16th March '20

Planning application 19/02796/F North Milton Rd. Adderbury

1 North Elevation
1 : 100

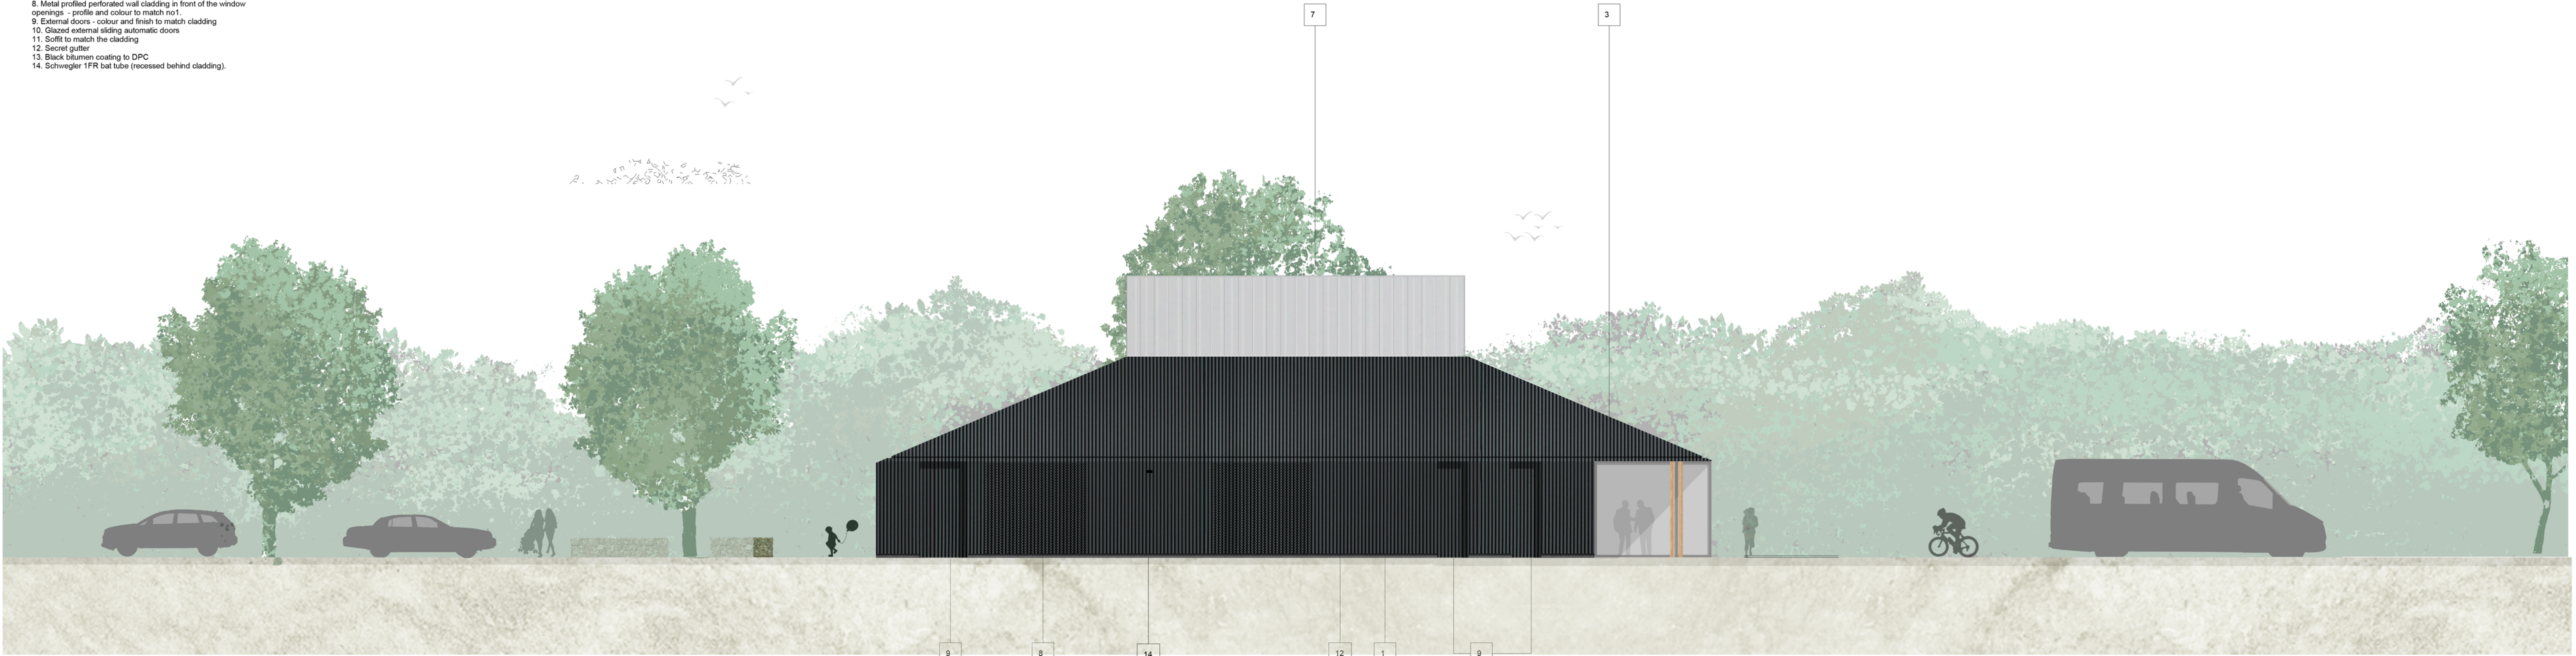
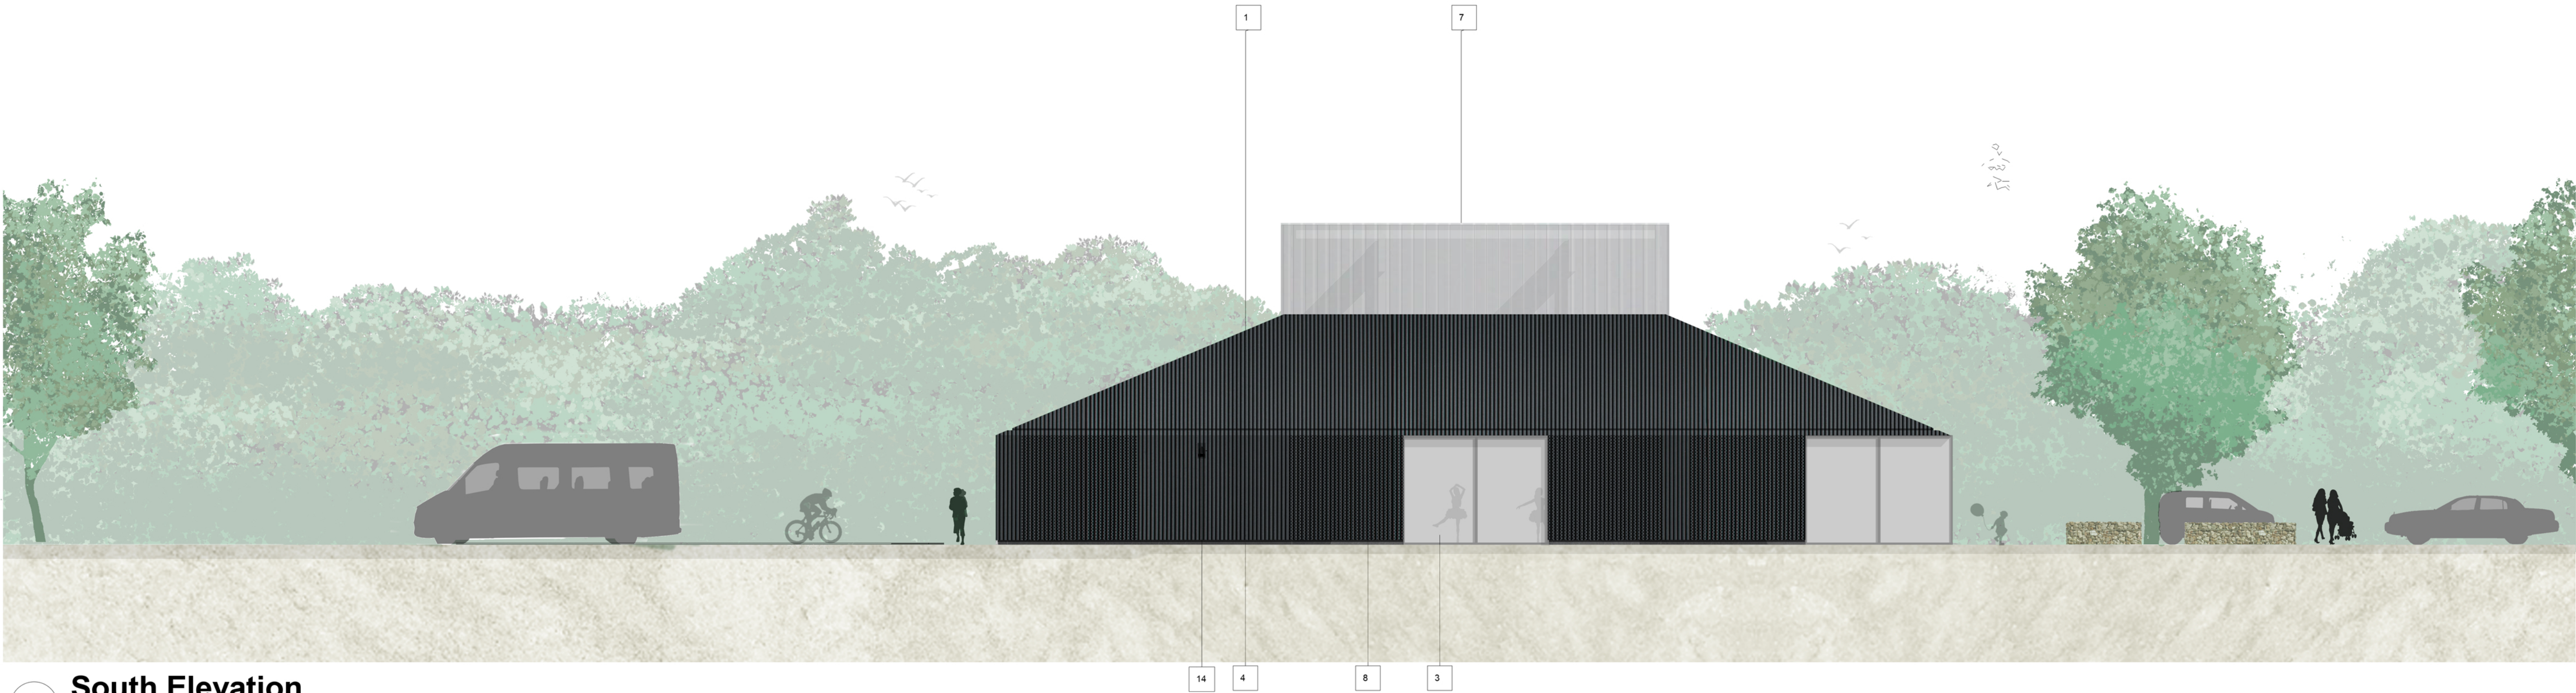
- The building materials are not good enough. Their low grade appearance will not stand the test of time and the village will be left with an unsightly, shabby building.
- The siting of the building and car park have shown little thought. Whilst the best location would be in the NW corner of the field, I realise for economic reasons it has been placed near the road. The SW corner would show much more consideration for those residents in Clockmaker's Turn.
- With this in mind, I question the layout of the pitches. Surely they should be in a North/South direction?
